Our reference: ECM Doc ID: 7615450  
Your Ref: SSD 6917 MOD 1  
Contact: Mathew Rawson  
Telephone: (02) 4732 7522

**NOTIFICATION OF MODIFICATION REQUEST FOR OAKDALE SOUTH  
INDSUTRIAL ESTATE (SSD 6917 MOD 1)**

I refer to the Notice of Exhibition dated 22 November 2016 inviting Council comment on the modification application to modify the Concept Proposal and Stage 1 Development Application for the Oakdale South Industrial Estate, located at Milner Avenue, Kemps Creek (Lot 12 DP 1178389 and Lot 87 DP 752041).

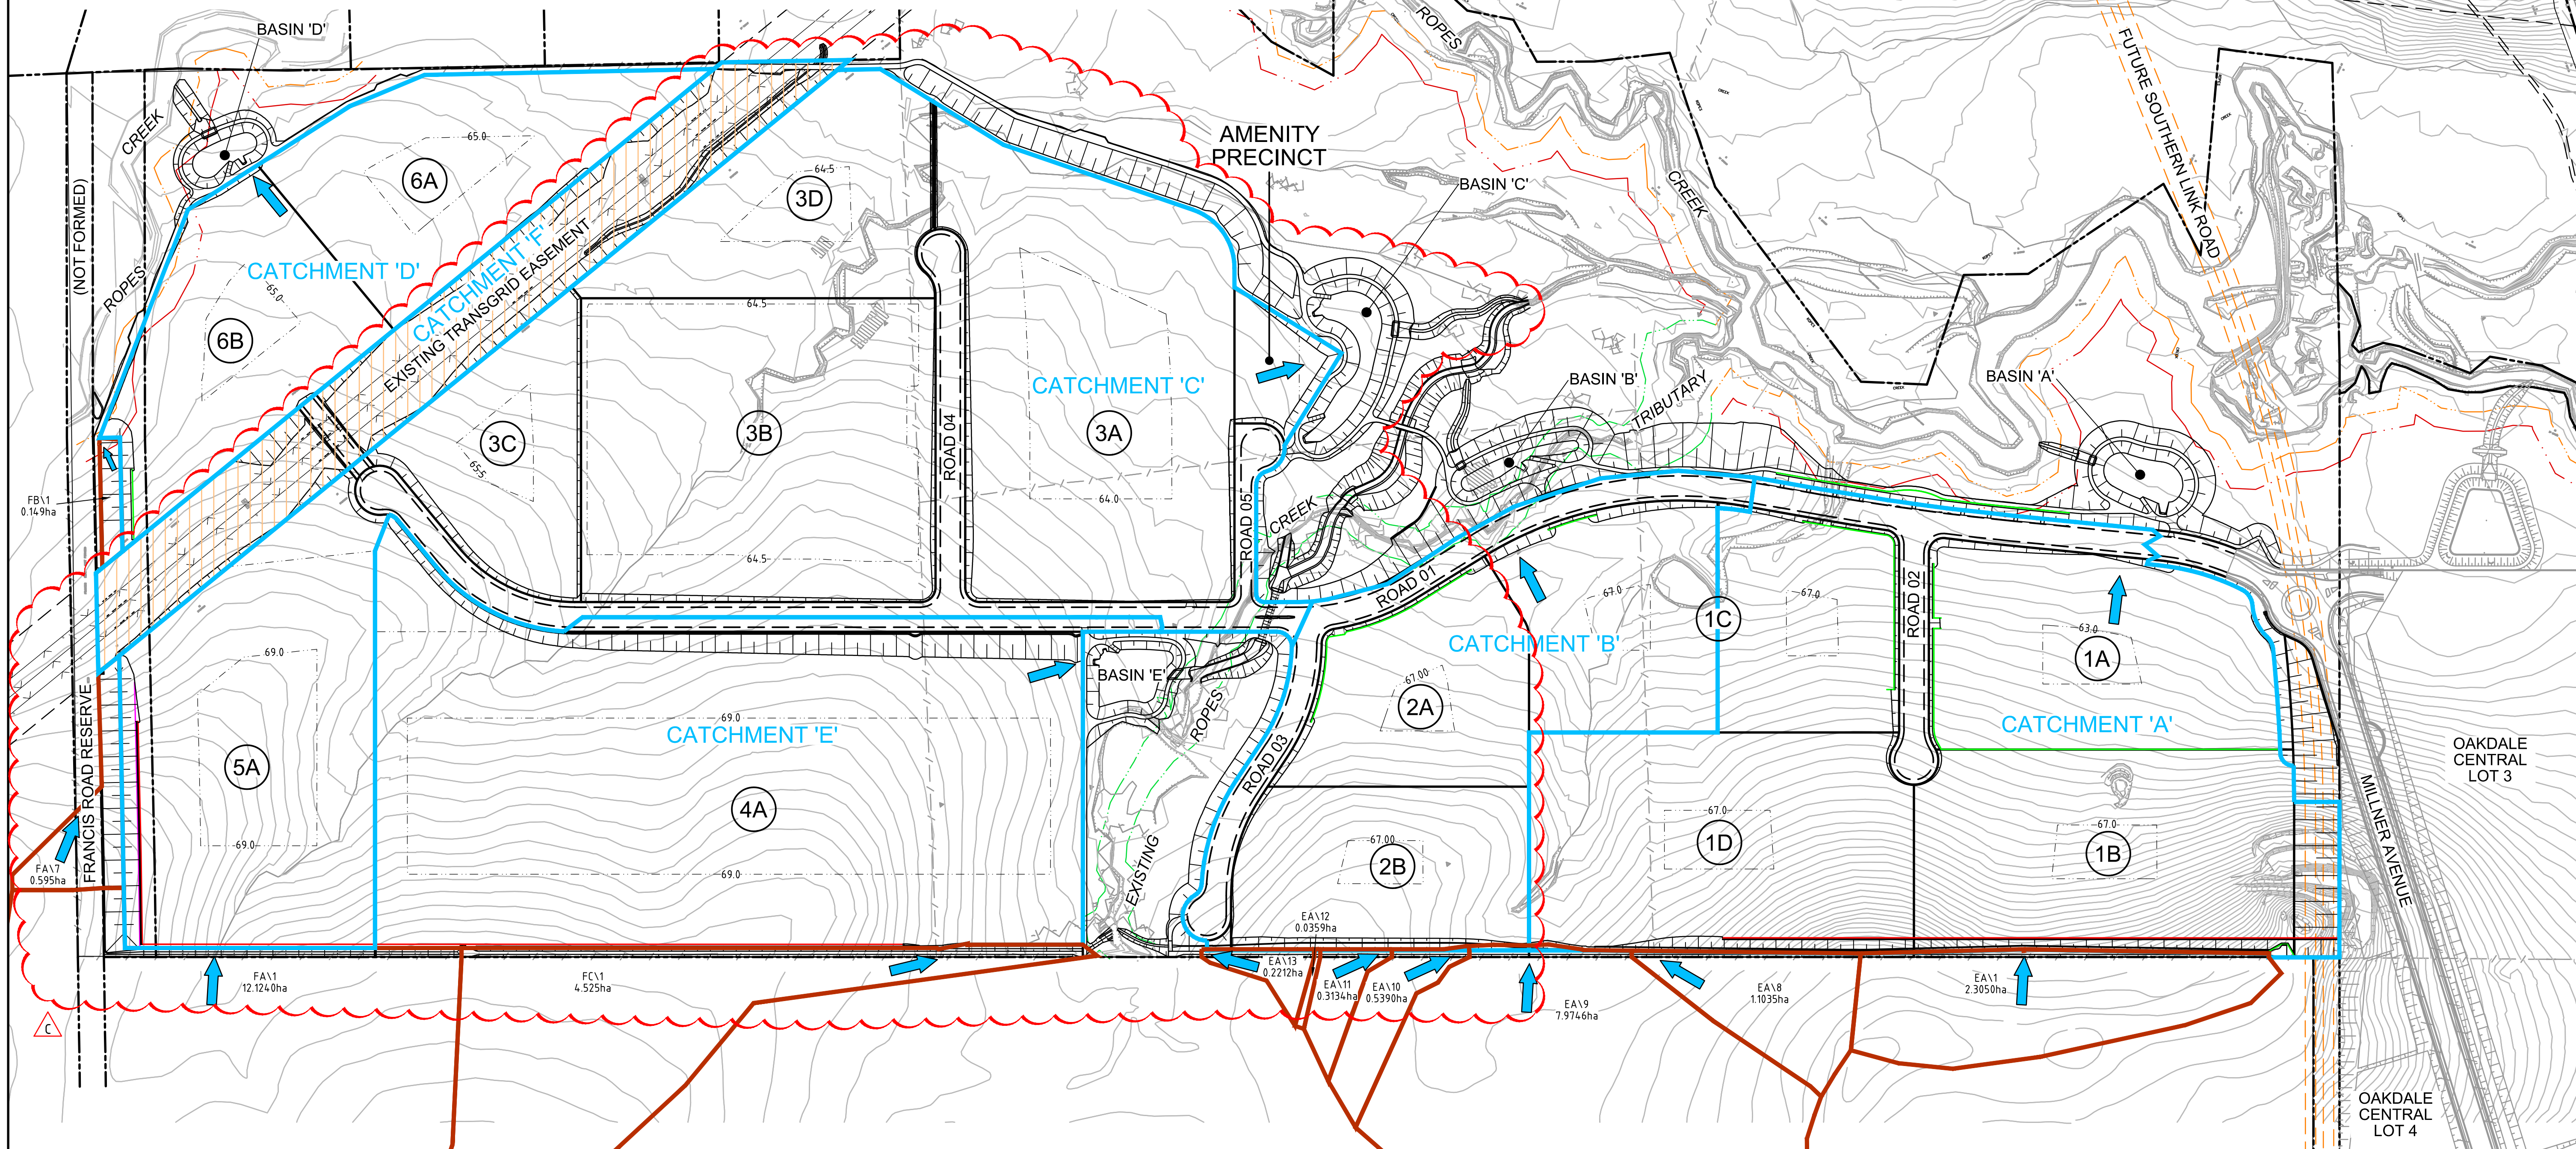
- Council's policy requires that all industrial sites treat their stormwater discharge on-site for both water quantity and quality prior to discharge into Council's drainage systems.

- Larger communal basins that are proposed to be handed over to Council are not supported as they place additional burdens upon Council's maintenance budget. No objections are raised to the basins being owned and maintained by the occupants/owners of the industrial lots.

- All bio-retention basins shall be designed to contain flows for all storm events up to and including the 1% AEP local storm event.

- Storage greater than 400mm above the bio-retention system intended level is not recommended as it can adversely impact on maintenance costs due to higher volumes of stormwater, increased pollutants and impacts on vegetation. However given that the basins will remain in private ownership and under private management Council has no objection to this storage arrangement.

**SSDA Masterplan**

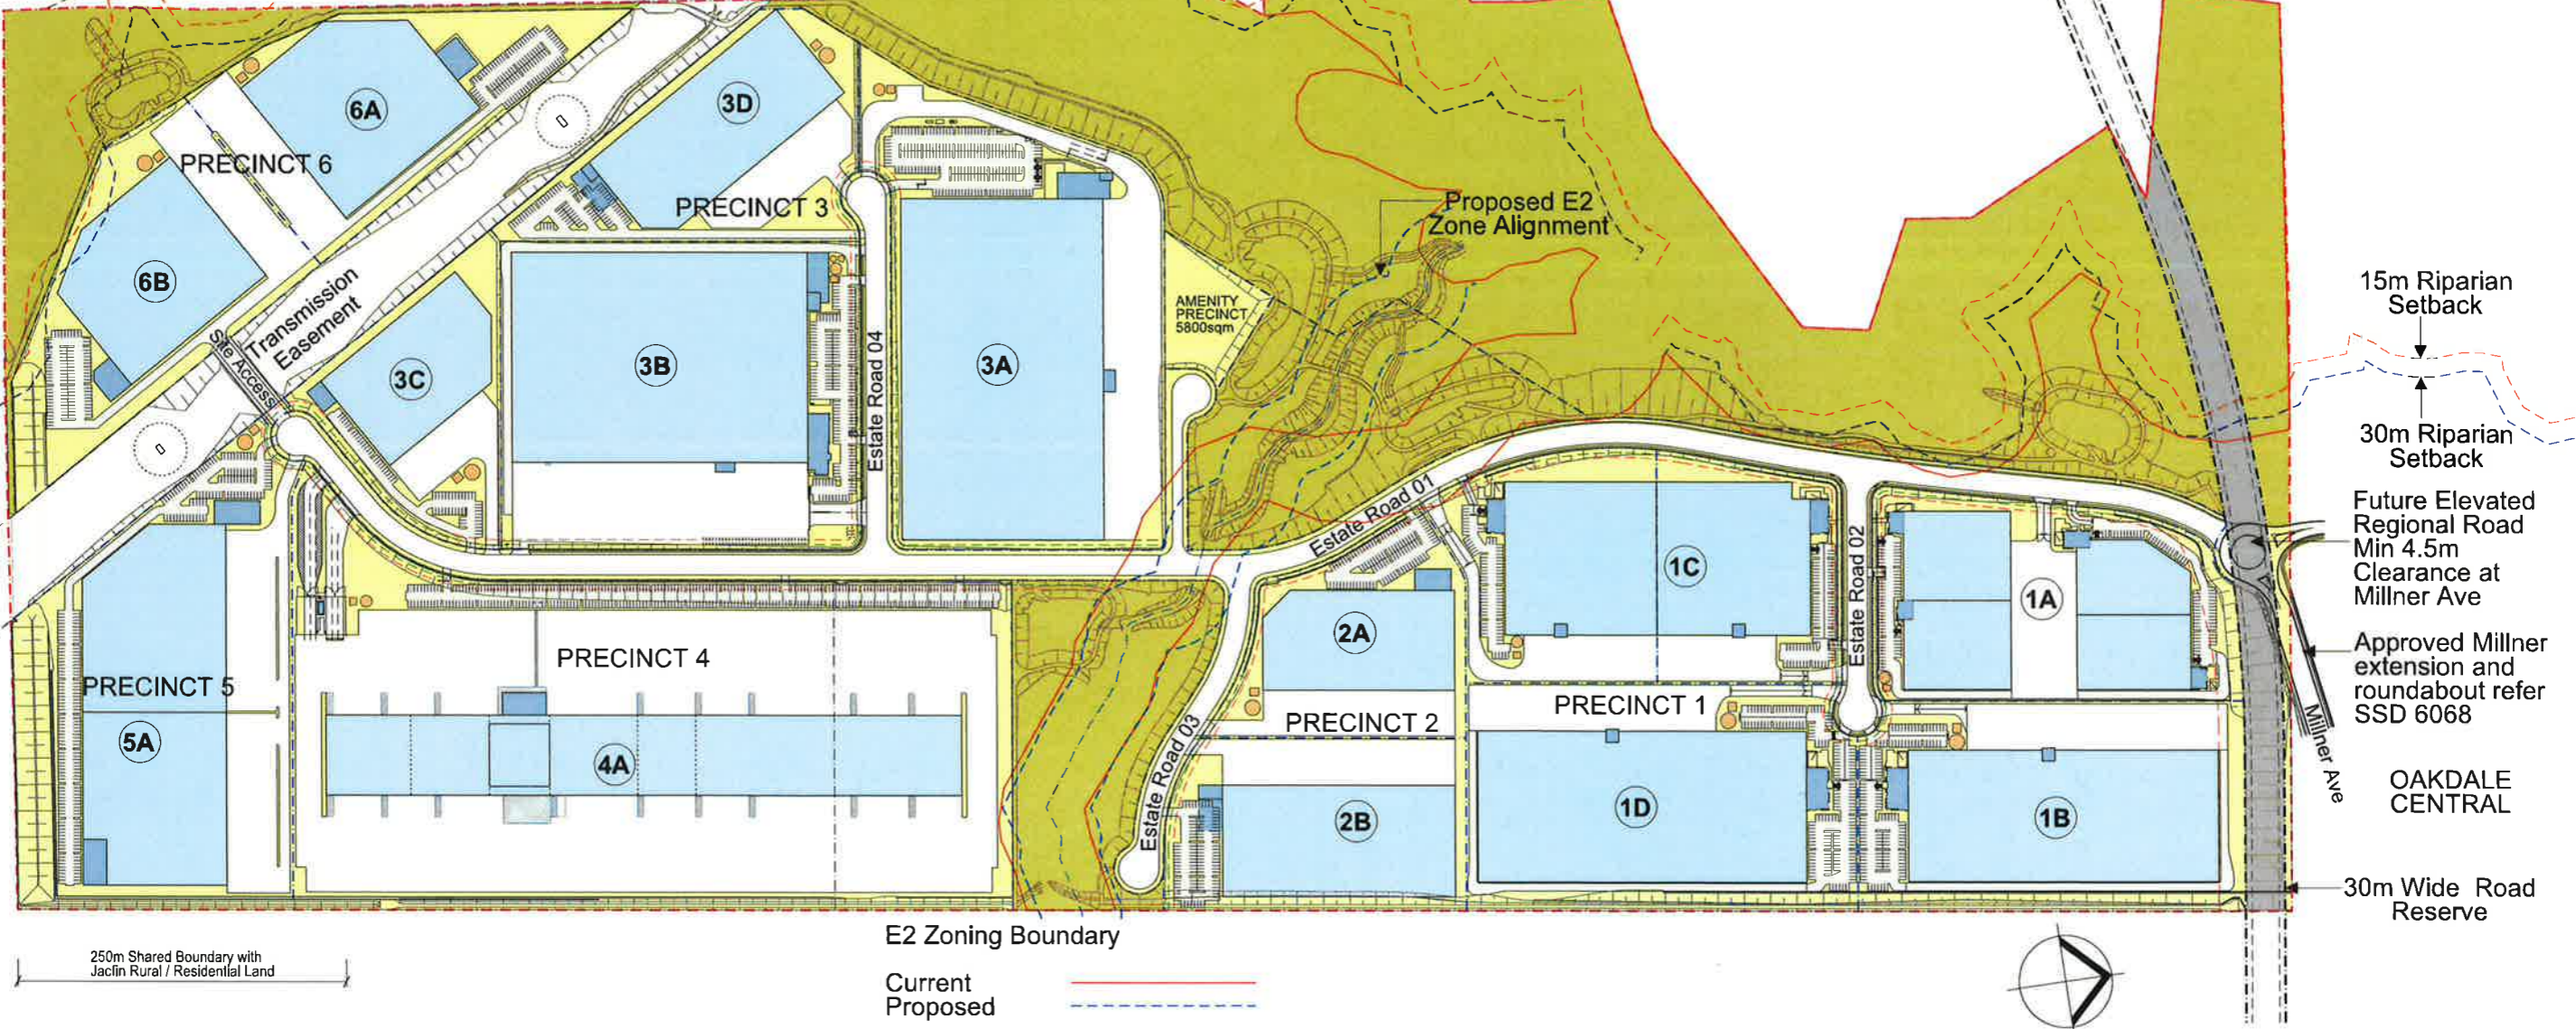
Council raises concerns regarding the modified building concept for Precincts 3, 4 and 5. These concerns relate to the orientation of the warehouses, the location of parking areas and loading docks as well as a reduction in land available for landscaping relative to the previously approved application.

It is noted however that the construction of these precincts has been removed from the proposal. The design of the Precincts may be addressed through subsequent development applications.

Eastern Boundary Landscape Section

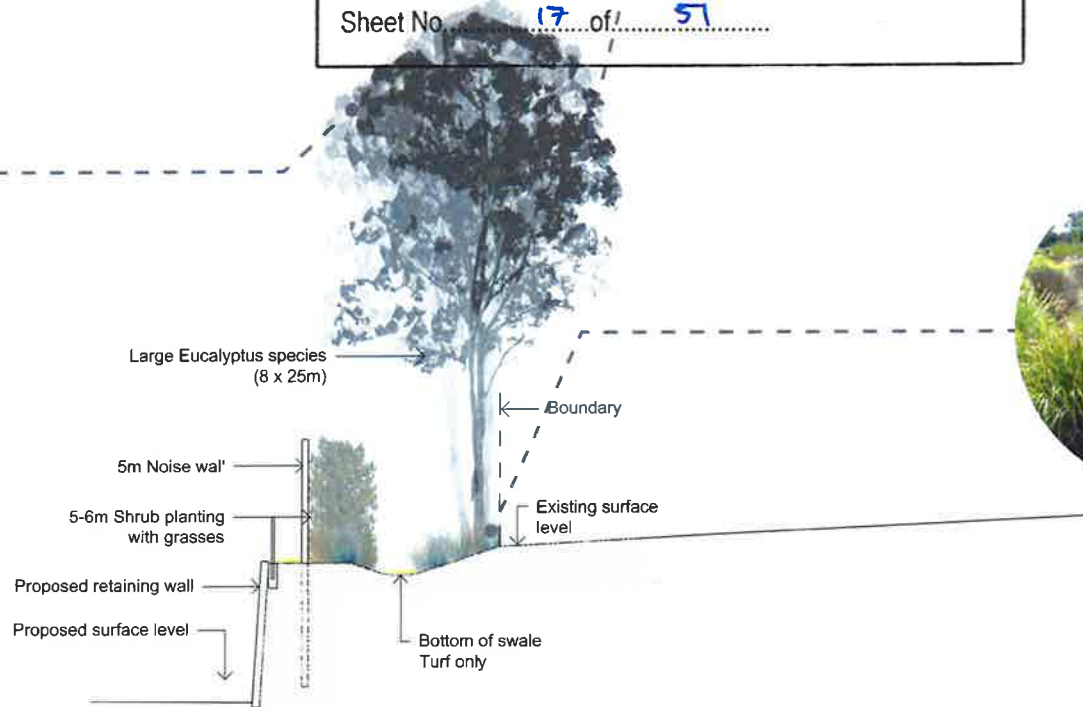
Given the likely building layouts for Precincts 4 and 5 as well as the extended noise wall required, it is considered that the 30 m setback with 5 m high landscaped mound should also be provided along the eastern boundary where the site directly adjoins the RU4 zoned 'Jacfin rural-residential' land. This will ensure that the noise wall and new industrial buildings will be adequately screened from view of the rural-residential allotments which will increase their future amenity.
